# Rezoning Transportation Analysis

Petition Number: 2020-161

General Location Identifier: Tax ID 03327114

Date	Description
12-28-2020	First Review (EL)
1-21-2021	Second Review (EL)
02-24-2021	Third (LJ)

**THE HUMAN BEAN**  
**LONG CREEK VILLAGE**  
**CHARLOTTE, NC**  
**ZONING EXHIBIT**

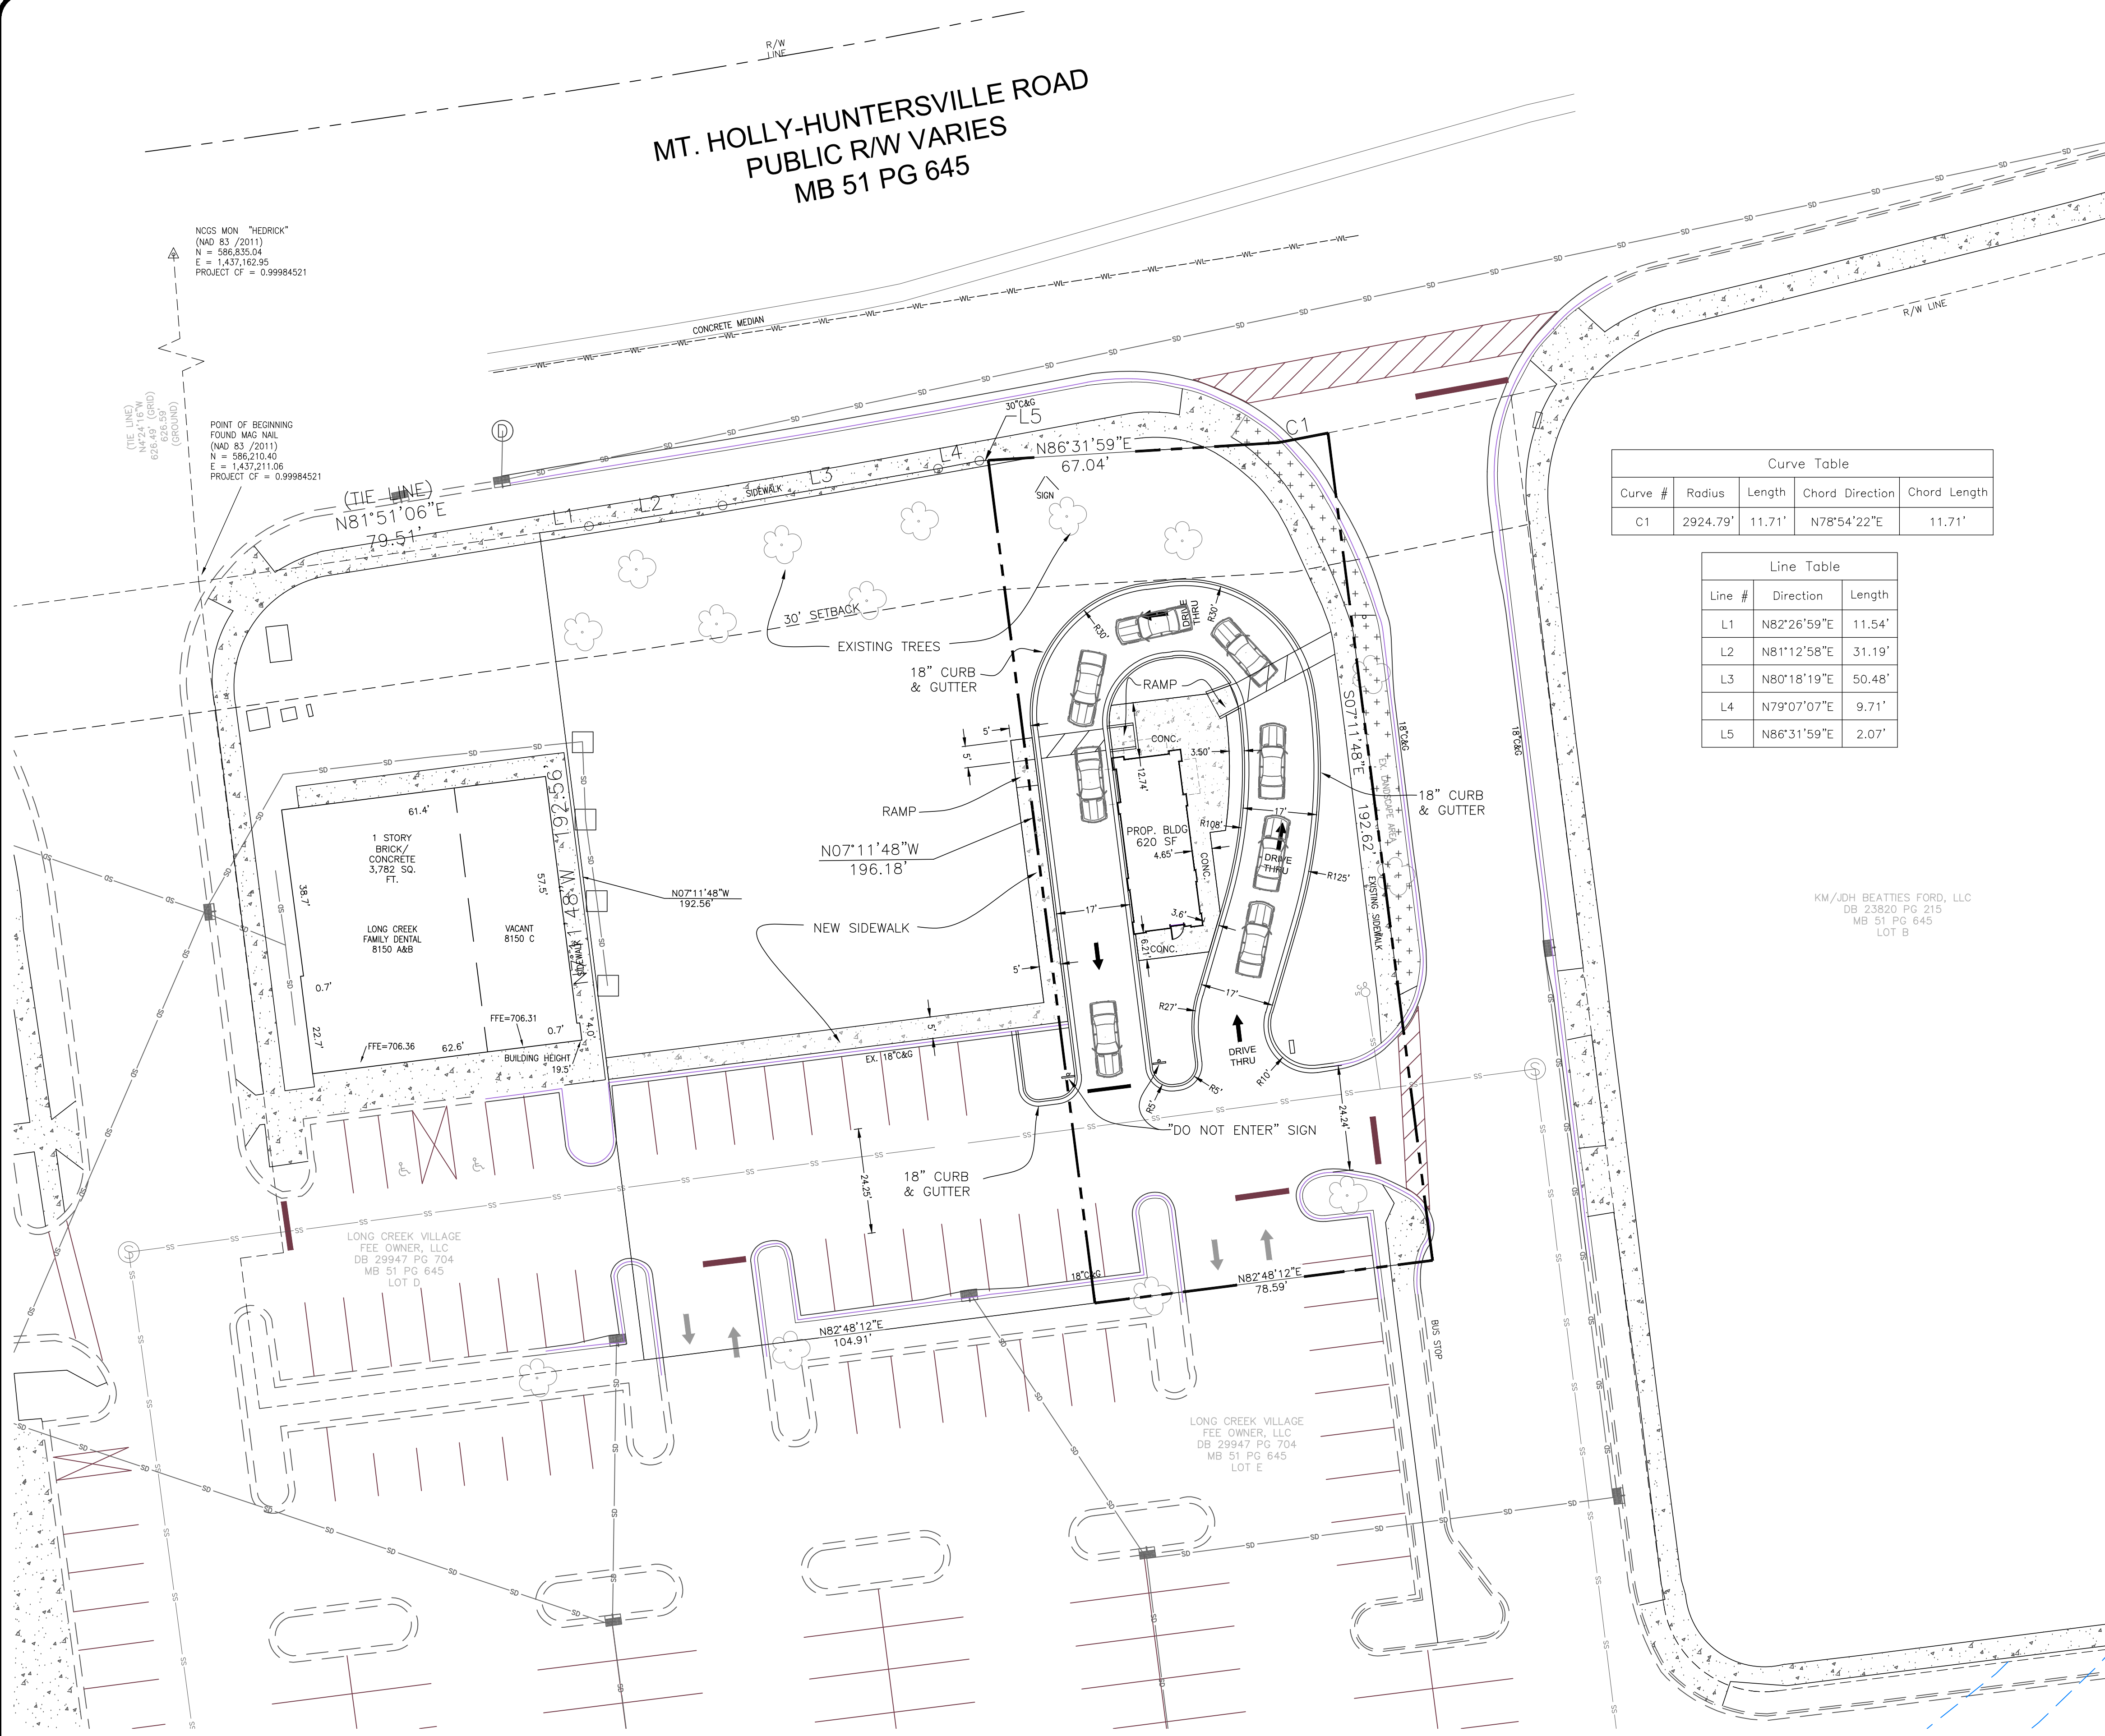
3. ~~Revise site plan and conditional note(s) to commit to dedicate a minimum of 50 feet of public right-of-way from the Mount Holly Huntersville Road centerline. CDOT requests additional public right-of-way to be dedicated 2 feet behind the existing sidewalk. The site plan shall label and dimension the right-of-way from the road centerline.~~

4. ~~Revise site plan and conditional note(s) to commit to construct bicycle facilities by installing a 12-foot shared-use path to meet the City Charlotte BIKES Policy.~~

7. ~~Technical Clarification (site plan dated 1-10-21) Revise the site plan and conditional note (Section Transportation.E.) to dedicate public right of way or a sidewalk utility easement at the location below.~~
